## 199 Woodford - Sign permit #01100

**Christina Stacey** <cstacey@portlandmaine.gov>  
To: jwolfe@waltonsignage.com

A D/F ILLUMINATED MONUMENT SIGN
Scale: 3/8" = 1'-0"

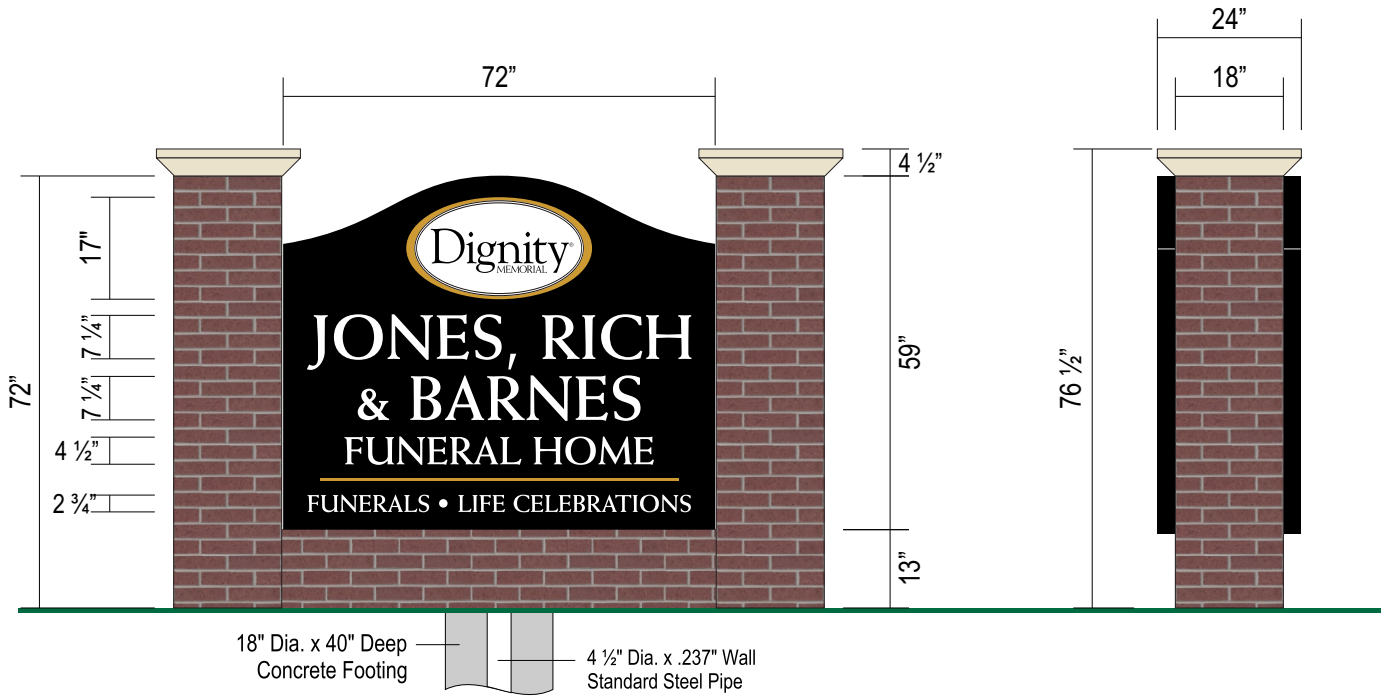
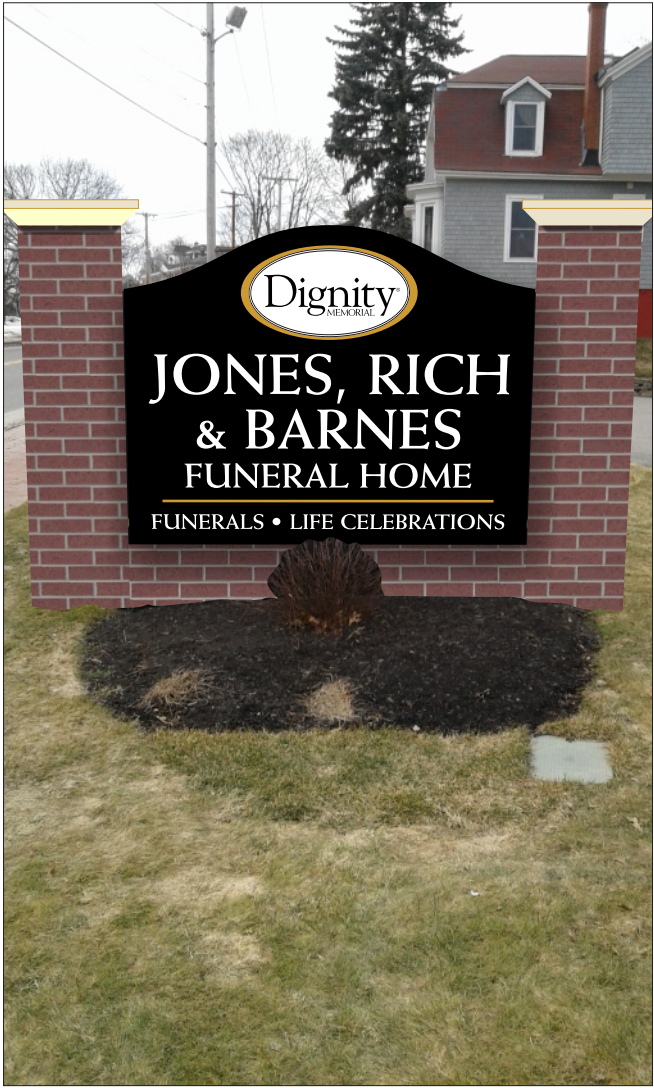
I am reviewing your sign application now, but have to admit to being confused by whether the sign will still meet the 5' property line setback, once the brick pillars are added. It looks like the existing sign is exactly 5' from the front property line. Are you planning to move it back slightly to accommodate the added pillars? The whole sign needs to be 5' from the line.

Yes, we will be relocating the new sign to meet the 15' setback to accommodate the pillars.

Great, thanks - I assume you mean 5' and not 15'! ;-)  
[Quoted text hidden]
